From: Martin Kempshall [REDACTED]
Sent: 05 June 2020 15:09
To: Russell McCourty
Cc: CEP | Reception
Subject: 23262 - Y/29/20/DOC - Former Reptune Garage, Main Road, Yapton
Attachments: Technical Note - Discharge of Condition V1.3.pdf; 501_C_Proposed Construction Details.pdf; 101_E_Schematic Drainage Strategy Plan.pdf

Following on from our recent conversation please find below our latest response with regard to the outstanding queries on the Discharging of Condition 4 (in green). Updated drawings and supporting information is attached.

Ref: 23262 – Reptune

CLIENT		Mr Pete Mountford
PROJECT		Reptune Yapton West Sussex
TITLE		Proposed Layout Drainage Strategy Plan
DRAWN	DATE	PROJECT NO.
M Pacifico	Nov 2019	2326
ENGINEER	CHECKED	DRG NO.
M Kempshall	SRM	101
SCALE	1:200 @ A3

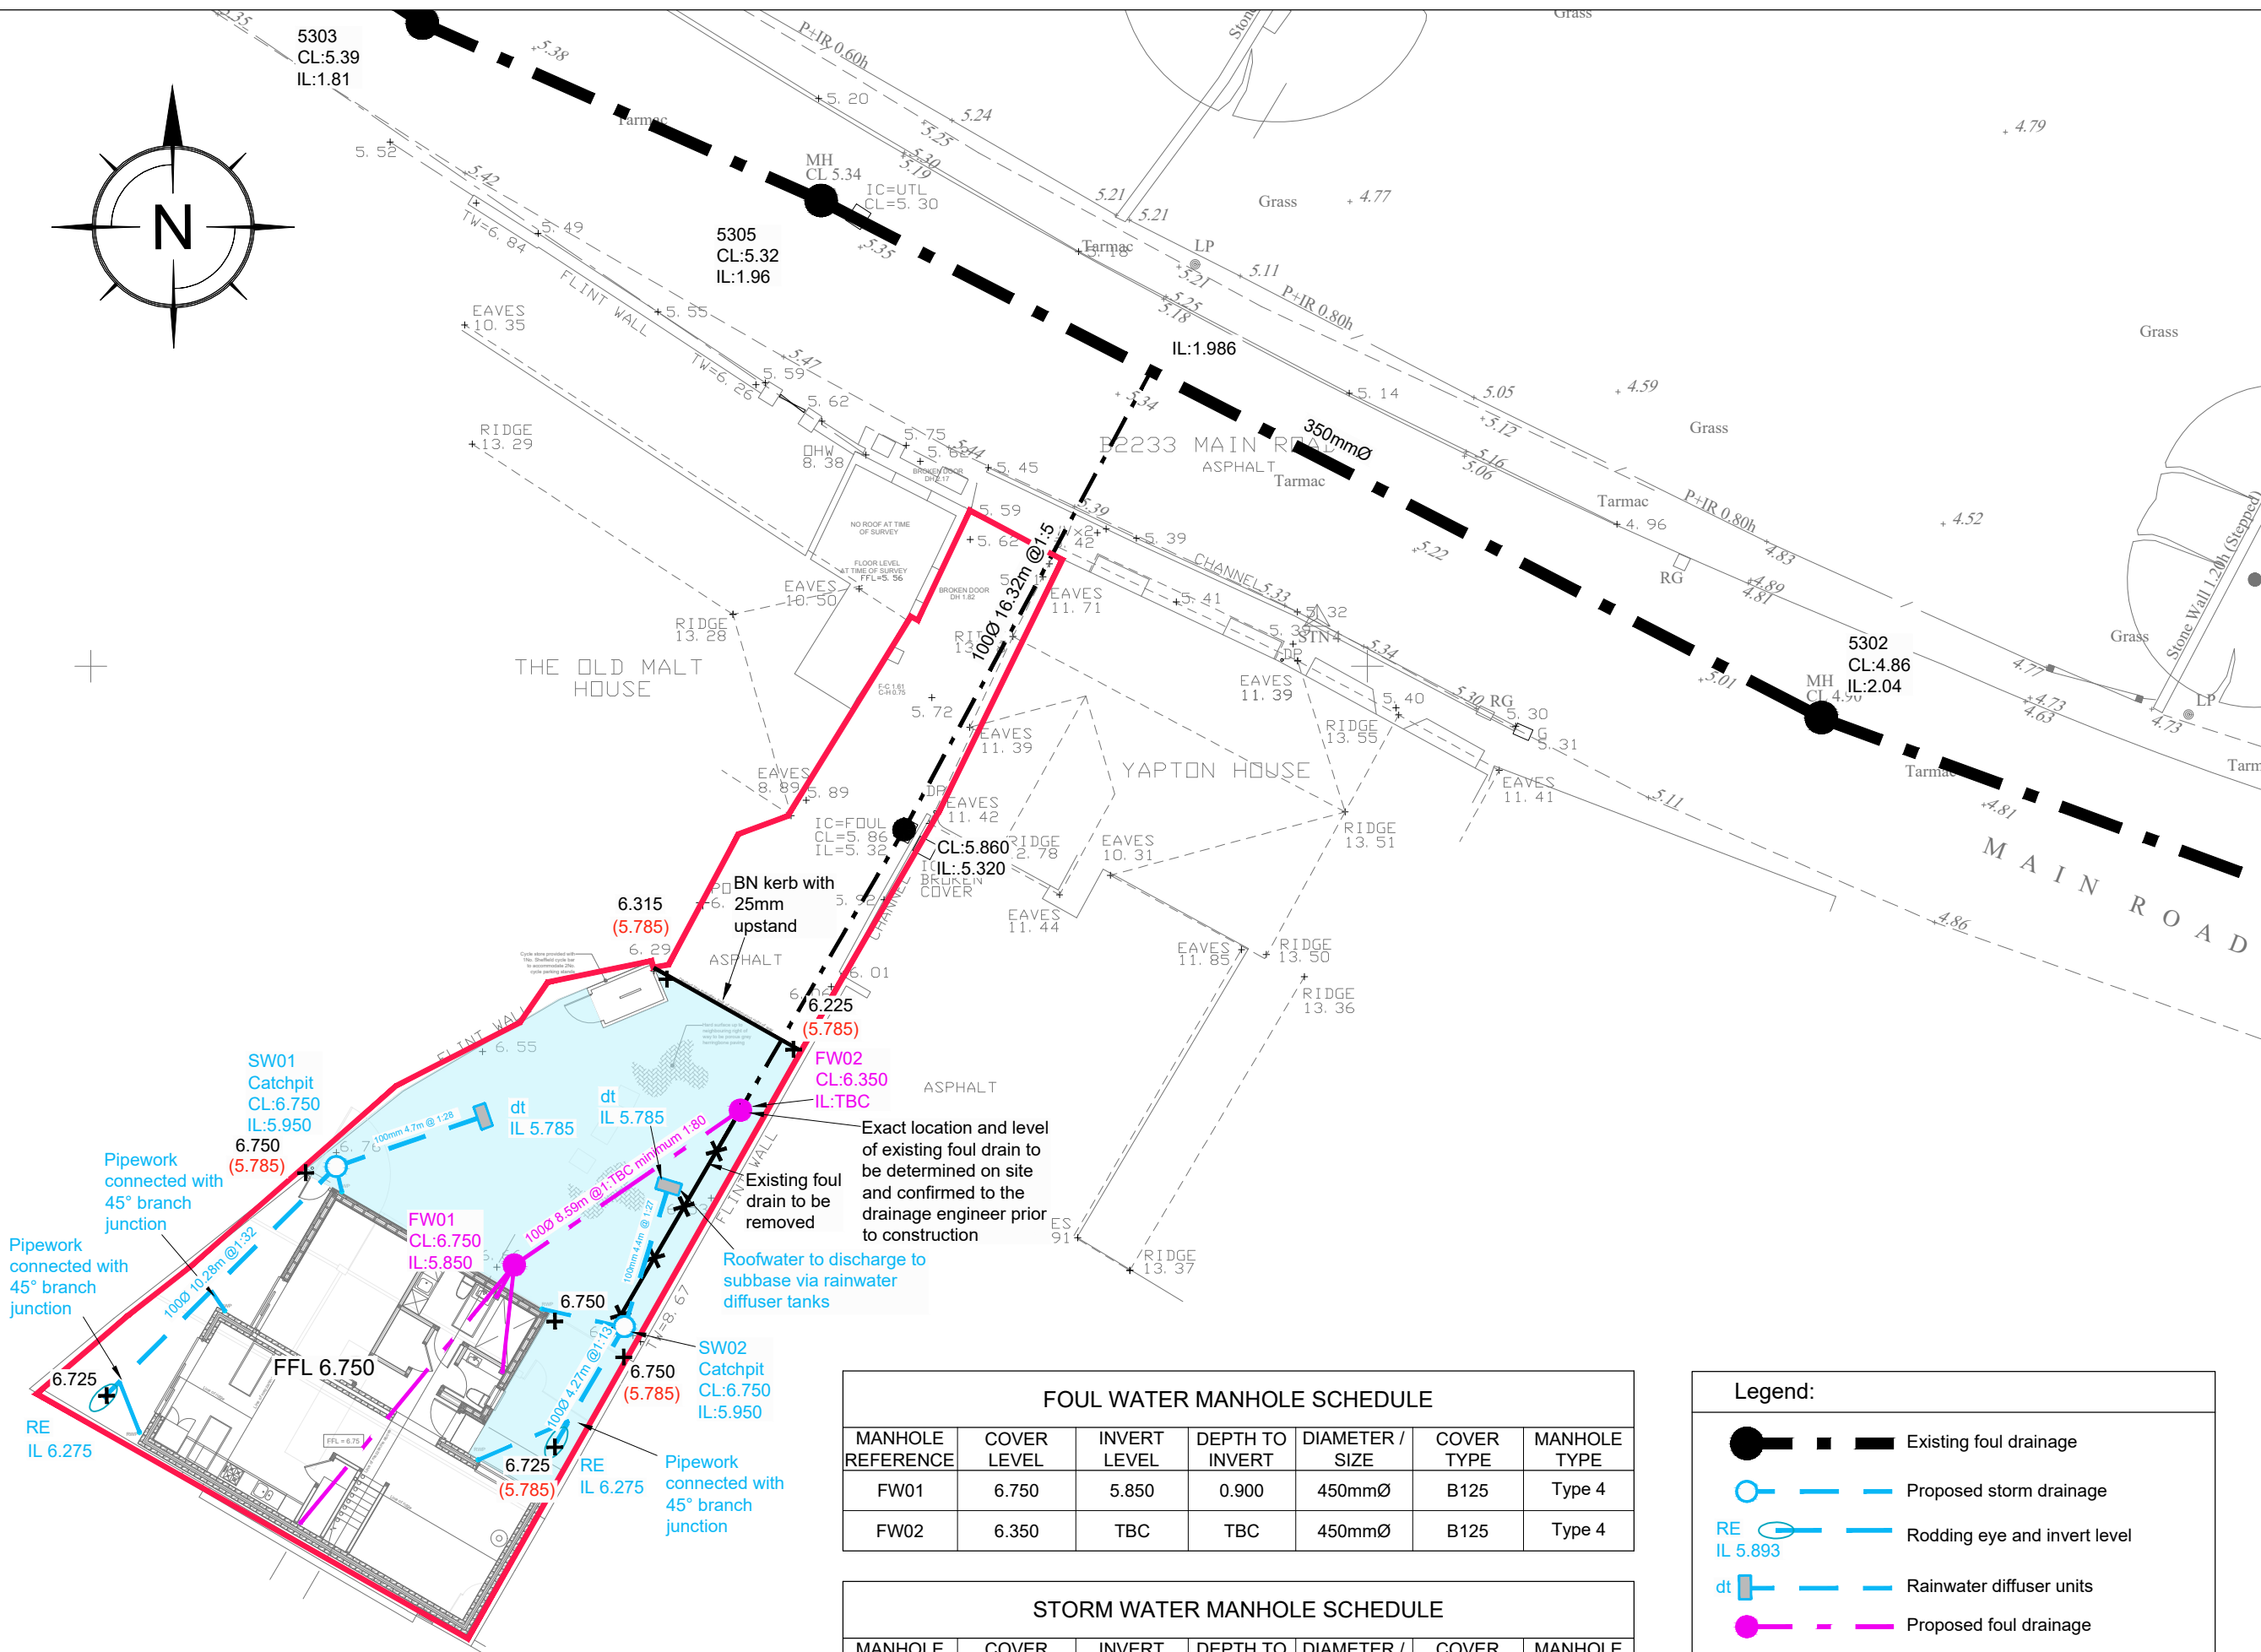
- 2) The extent of the proposed new paving is shown on the drawings which is reflected in the areas of the infiltration blanket within the supporting calculations. The drainage strategy plan, attached again for quick reference, shows no surface treatment changes to the Northern end of the site. The blue shaded area is the area subject to resurfacing. Noted

- 3) This is a design preference and not a planning related requirement which is beyond the remit of a consultee at Planning Stage. We are the designer and can choose between either the use of perforated pipe or diffuser units as both are acceptable designs. Disagree – as part of our appraisal, we consider the robustness of the scheme design. Diffuser units are far more robust in terms of resisting loading from vehicles. Perforated pipes far less so. We have consulted with our Client and in this instance they are happy to use a diffuser unit. There is no obligation to place diffuser units 5m from buildings in any known guidance, again this is considered a design preference. Building regulation requirements specifically relates to soakaways due to highly focus areas of water discharging directly into the ground around building foundations, which is not the case for diffuser units proposed which disperse surface water into a wider area of voided subbase. Local Building Control officers sometimes have a preference to have the diffuser units 5 metres away from buildings, since this is the point where water flow is initially concentrated especially in lesser storm events. Amended drawings noted.

- 10) Additional levels added and subbase thickness updated to reflect the assumed CBR. There is a significant slope on the permeable paving formation level, based upon the finished surface levels provided. The calculations will need to take account of this slope, to ensure that the 1 in 100 year event + 40% is contained within the structure. There is no parameters shown in the calculations to suggest that the slope has been accounted for.

- 2) The extent of the proposed new paving is shown on the drawings which is reflected in the areas of the infiltration blanket within the supporting calculations. The drainage strategy plan, attached again for quick reference, shows no surface treatment changes to the Northern end of the site. The blue shaded area is the area subject to resurfacing. Noted
Noted – No Action

- 3) This is a design preference and not a planning related requirement which is beyond the remit of a consultee at Planning Stage. We are the designer and can choose between either the use of perforated pipe or diffuser units as both are acceptable designs. Disagree – as part of our appraisal, we consider the robustness of the scheme design. Diffuser units are far more robust in terms of resisting loading from vehicles. Perforated pipes far less so. We have consulted with our Client and in this instance they are happy to use a diffuser unit. There is no obligation to place diffuser units 5m from buildings in any known guidance, again this is considered a design preference. Building regulation requirements specifically relates to soakaways due to highly focus areas of water discharging directly into the ground around building foundations, which is not the case for diffuser units proposed which disperse surface water into a wider area of voided subbase. Local Building Control officers sometimes have a preference to have the diffuser units 5 metres away from buildings, since this is the point where water flow is initially concentrated especially in lesser storm events. Amended drawings noted.

- 10) Additional levels added and subbase thickness updated to reflect the assumed CBR. There is a significant slope on the permeable paving formation level, based upon the finished surface levels provided. The calculations will need to take account of this slope, to ensure that the 1 in 100 year event + 40% is contained within the structure. There is no parameters shown in the calculations to suggest that the slope has been accounted for. The formation level of the subbase will be flat as per the infiltration blanket calculations, the formation levels have been added to the drawings.

PERMEABLE BLOCK PAVING CAR PARK DETAIL (Scale 1:20)

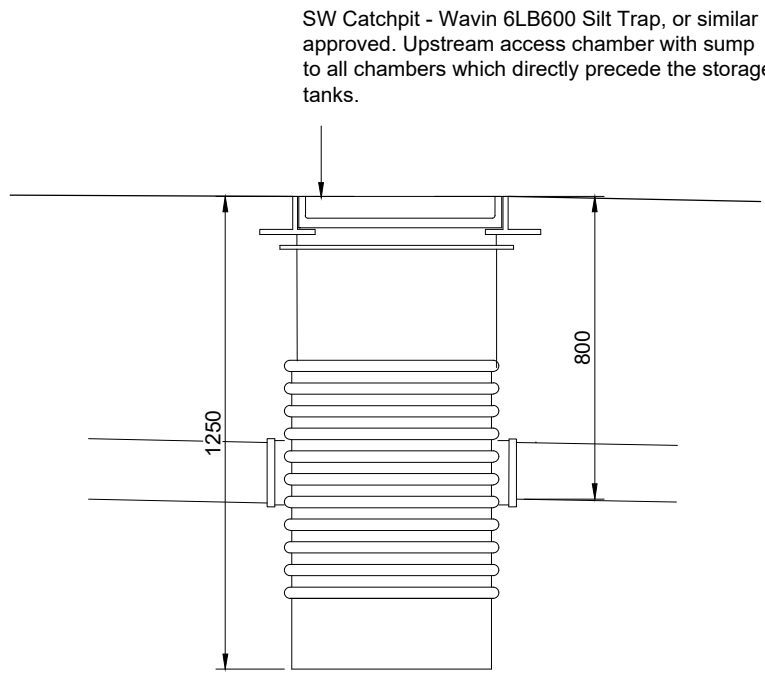
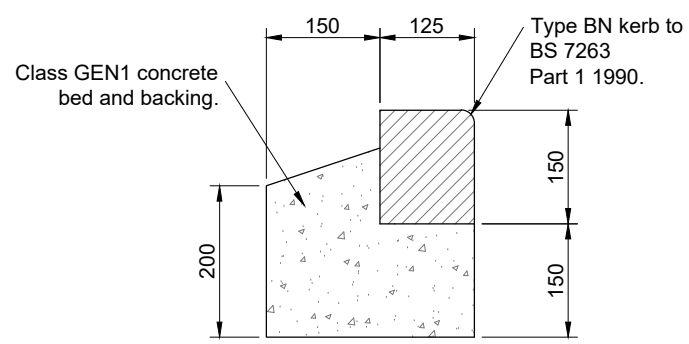
how much silt can be produced from a roof, especially when moss's etc become established on the tiles over time. Please add sump depth (min. 300mm) to construction detail.

- 5) Added where not shown – The foul water pipe connecting proposed FW01 and FW02 will not be known until construction and the minimum fall has been stated. Specify pipe diameter and gradient between catchpits and diffuser units. Also indicate pipe invert level/finished paving level at connection to diffuser unit – to show that the pipe can be suitably connected based upon the proposed construction depth of the permeable paving.

- 6) Added. ok
- 7) Added where required. ok
- 8) This is a design preference. We have not shown this as there no practical reason or benefit in doing so. The request would require laying asphalt directly onto the permeable membrane during the construction process. The contractor will need to ensure that no fines enter the sub base during the laying of the base course.

Noted – No Action
- 4) This is again a design preference. This is fundamental in ensuring that the risk of silt entering the diffuser unit is minimised, is good practice and provides a convenient chamber to enable silt removal. We have added silt traps upstream of diffusers in this instance, however diffuser units are only receiving roof water and any silt / sediment. Any loose sediments or fines are likely to be very low and unlikely to be significant enough to restrict performance of the diffuser units however we have determined in this case they are of benefit. It is surprising how much silt can be produced from a roof, especially when moss's etc become established on the tiles over time. Please add sump depth (min. 300mm) to construction detail.
The unit is specified and has a sump depth of 450mm, this has been added to the drawing.

- 5) Added where not shown – The foul water pipe connecting proposed FW01 and FW02 will not be known until construction and the minimum fall has been stated. Specify pipe diameter and gradient between catchpits and diffuser units. Also indicate pipe invert level/finished paving level at connection to diffuser unit – to show that the pipe can be suitably connected based upon the proposed construction depth of the permeable paving. This has been now been added and the construction detail also updated.

- 6) Added. Ok
Noted – No Action.
- 7) Added where required. Ok
Noted – No Action
- 8) This is a design preference. We have not shown this as there no practical reason or benefit in doing so. The request would require laying asphalt directly onto the permeable membrane during the construction process. The contractor will need to ensure that no fines enter the sub base during the laying of the base course. Noted – This detail has been updated on the latest construction drawing to reduce the thickness of formation and is now fully wrapped.
